SFD19533  
 PLAT 11176  
 PUD  
 ADU1931 MOTHER IN LAW  
 IN THE BASEMENT

**DISAPPROVED**  
**Plan Review**

EPC Planning & Community  
 Development Department

SFD19533  
PLAT 11176  
PUD  
ADU 1931  
Mother-In-Law

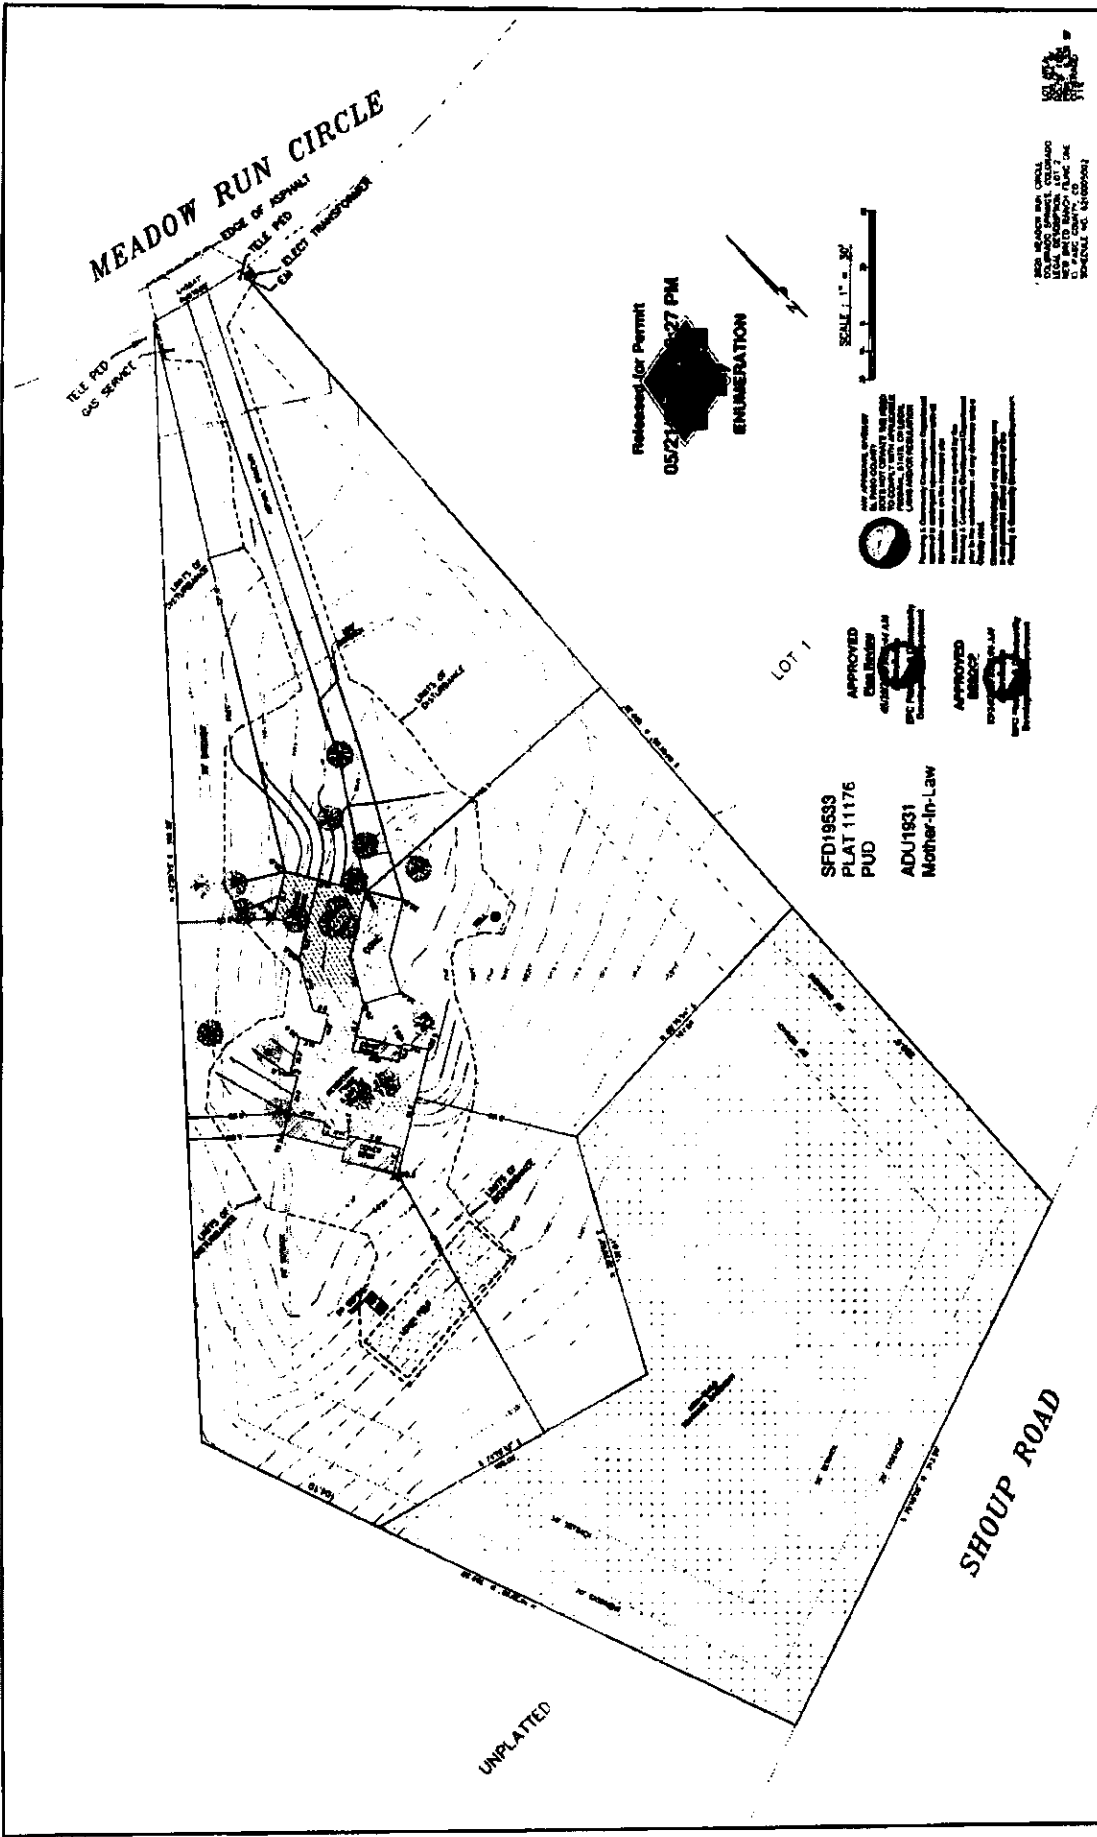
- (1) MISSING ACC LETTER OF APPROVAL
- (2) MISSING MOTHER-IN-LAW AFFIDAVIT
- (3) MUST IDENTIFY MOTHER-IN-LAW APARTMENT ON PLANS  
 (ADD STOVE TO PLAN)
